Application for a non-material amendment following a grant of planning permission.

3/2025/0372

PROPOSED REMOVAL OF EXISTING SHED AND CONSTRUCTION OF NEW DETACHED GARAGE AND WORKSHOP.

AMENDEMENTS TO PROPOSED ELEVATIONS - ADDITION OF DOOR, WINDOW AND STAIR TO SOUTH ELEVATION

Client:		
Mr S Jackson		
Project:		
Proposed Garage Planetree Cottage Chipping Road Chaigley		
Dwg title:		
Proposed Floor Plans		
Scale @ A4:	Date:	Drawn by:
1:100	28.11.21	PD
Drawing no.		Rev.
1319 - 01		C

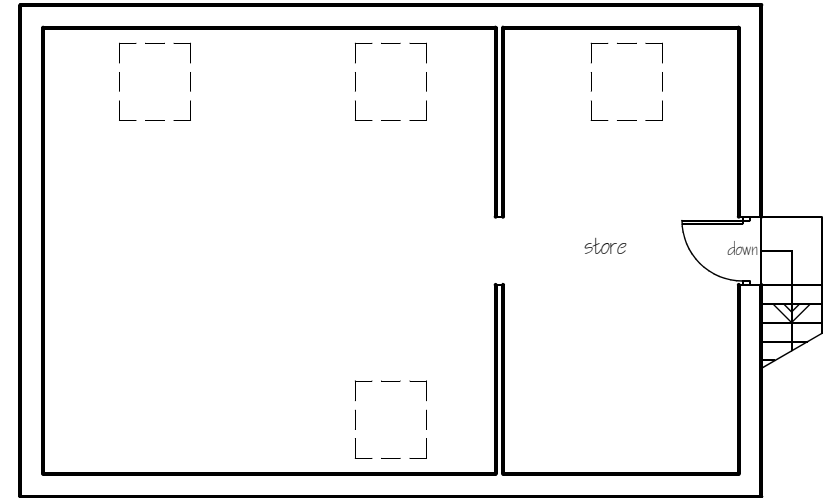
THE AMENDMENT IS TO PROVIDE AN EXTERNAL ACCESS STAIR & DOOR TO THE STORE AND A WINDOW TO THE WORKSHOP
